Plat V-1.pdf Markup Summary

TIS V_1.pdf Markup Summary

CD V_1.pdf Markup Summary

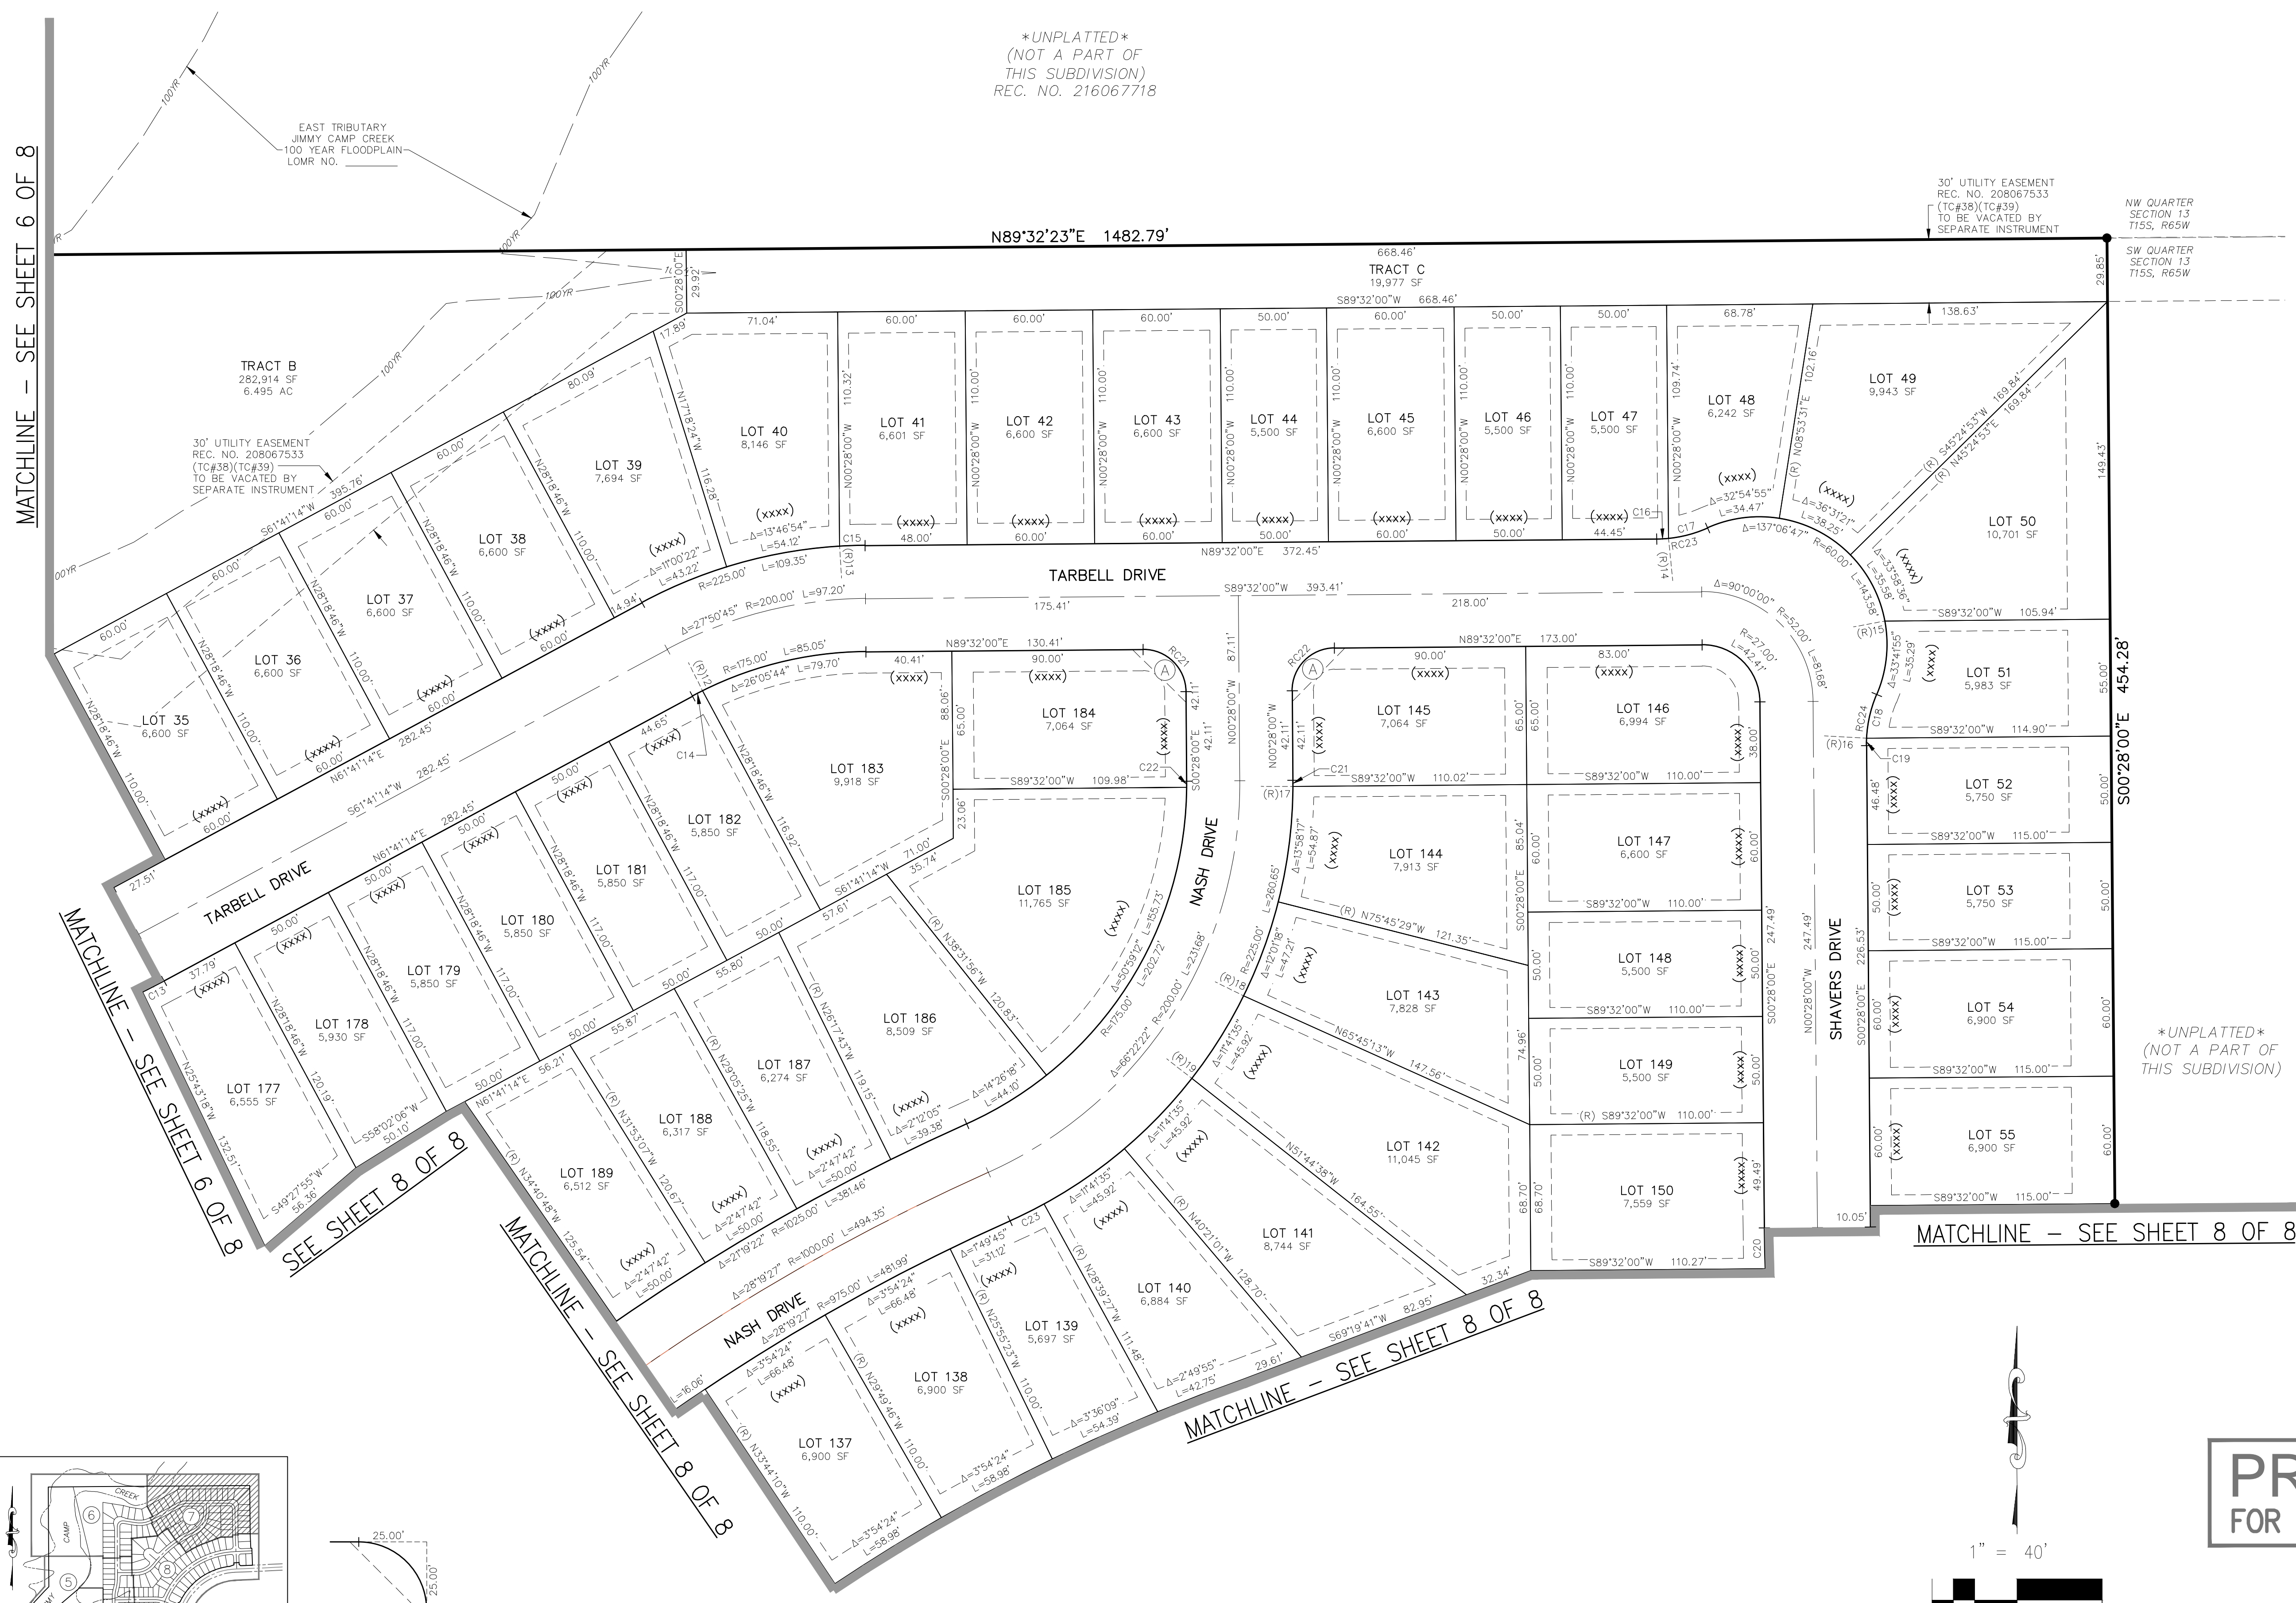
Is this the area that the SDS easement is in? Add leaders to clarify. The line type is different than the key map.
